REFUSAL OF PLANNING PERMISSION

APPLICATION NO. 2017/0026

Proposal Erection of new showroom with residential unit above.

At Barnsley Plumbing Centre, Rotherham Road, Cundy Cross, Barnsley, S71 5RF

BLOCK PLAN

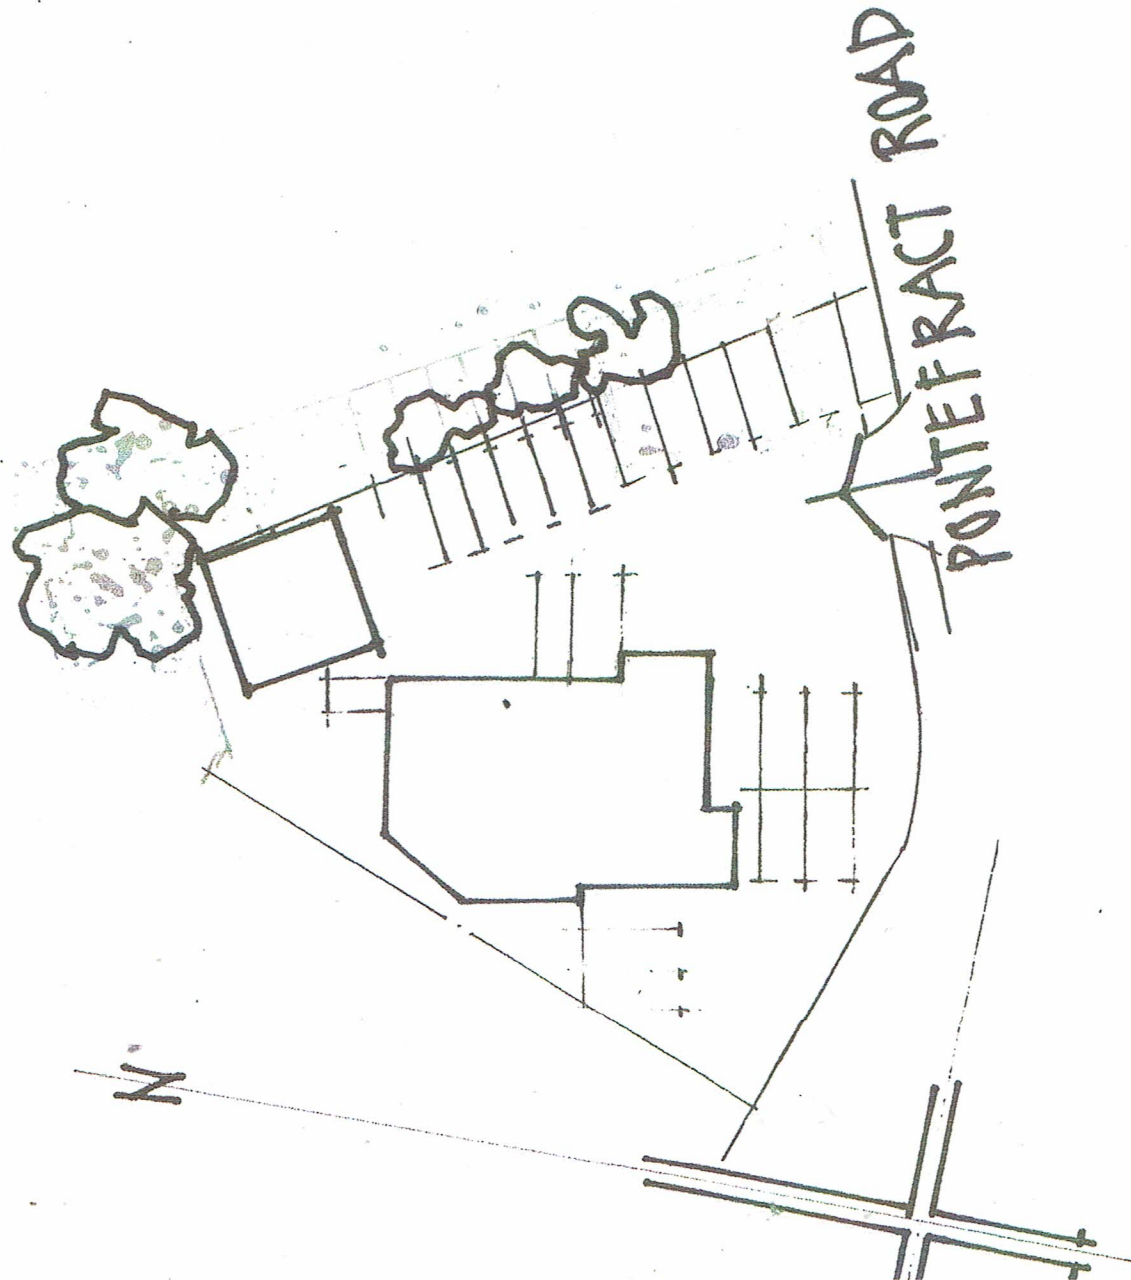
- 3 Despite requests for additional information the applicant has not submitted sufficient details to enable an adequate assessment to be made of the effect of the proposal on the surrounding road network and highway safety, contrary to CSP 26 'New Development and Highway Improvement'.

# PROPOSALS

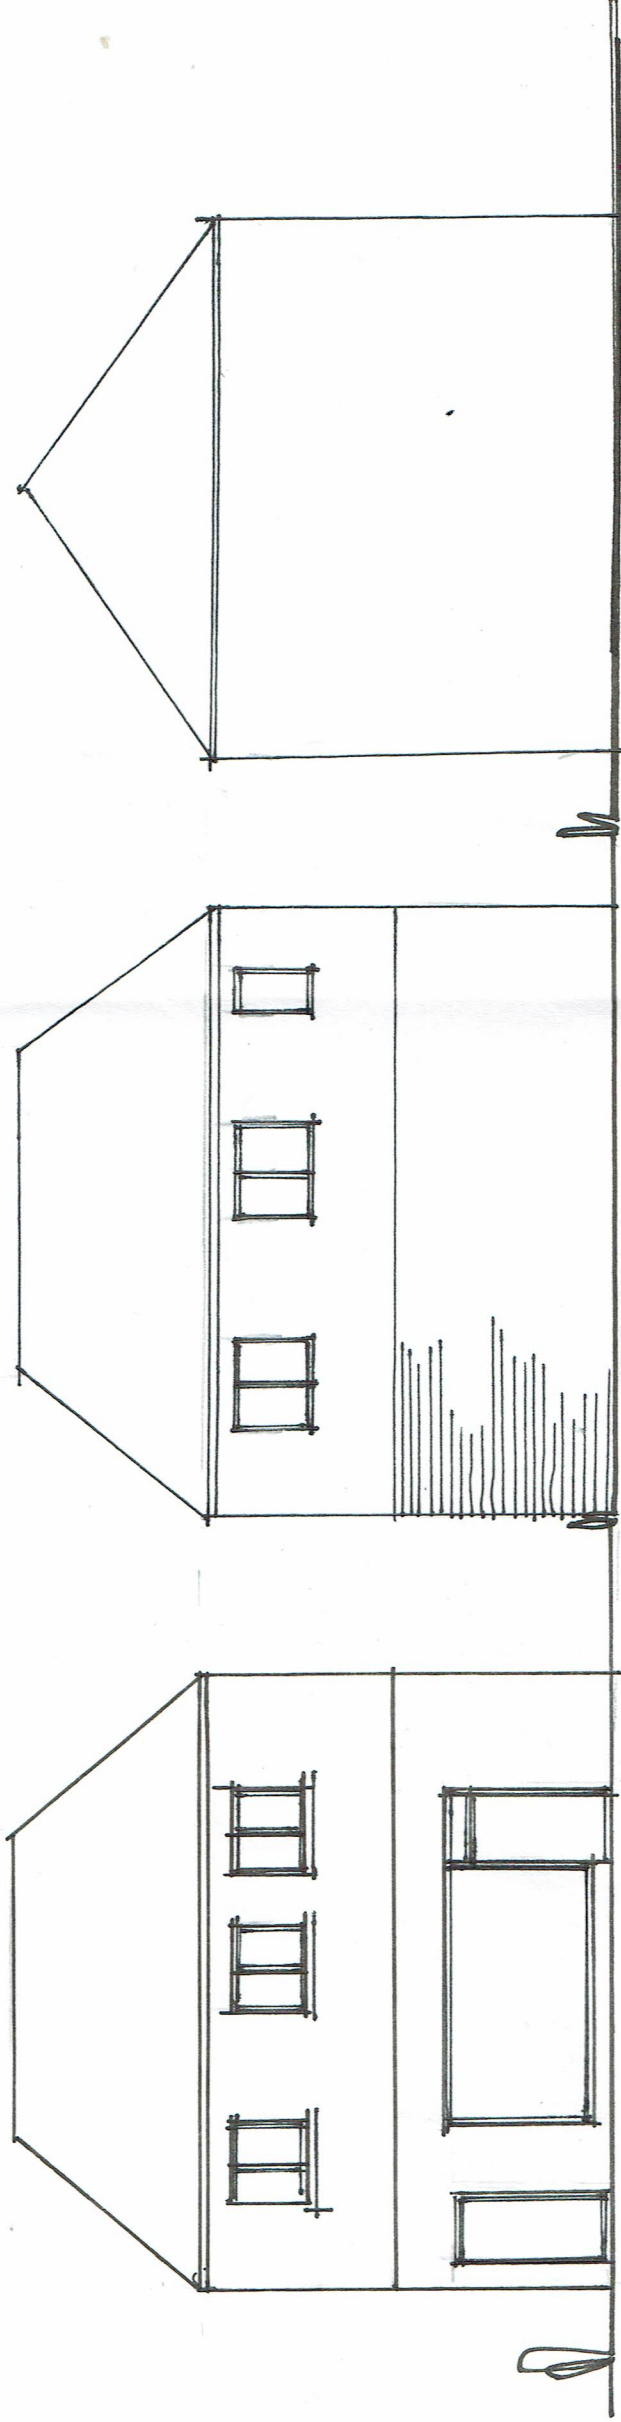
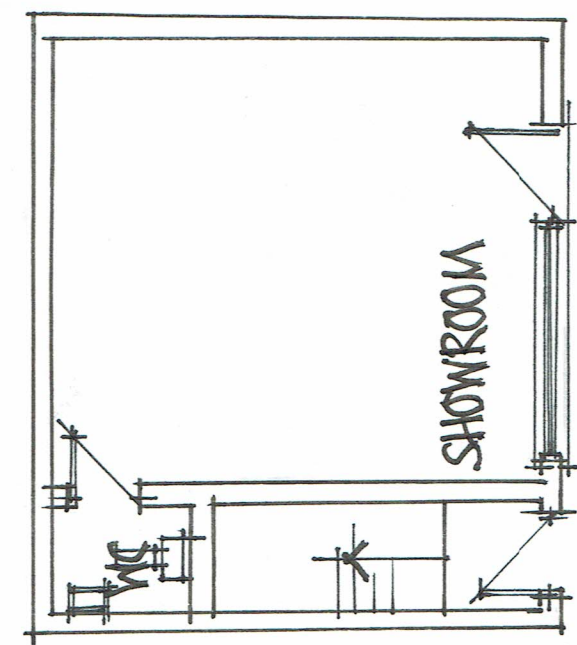
- 1 In the opinion of the Local Planning Authority the proposed building would be contrary to saved Policy ED10 of the Unitary Development Plan and Policy CSP 29 'Design' in the Core Strategy in that its design, layout and positioning would not harmonise with the host property and, as such, it would appear a cramped and incongruous addition. As a consequence the building would be materially detrimental to the visual amenities of the locality.

FIRST FLOOR

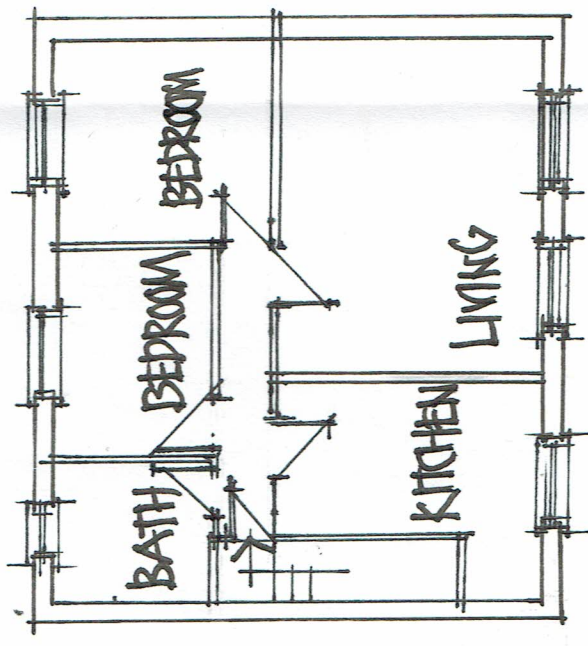
- 2 The internal spacing standards of the proposed residential unit fall significantly below those set out in the Technical Requirements of the South Yorkshire Residential Design Guide and referenced in Supplementary Planning Document 'Designing New Housing Development'. Furthermore, the occupants of the unit would have a poor outlook and no access to private outdoor amenity space. As such, the development would result in inadequate levels of residential amenity for future occupants.
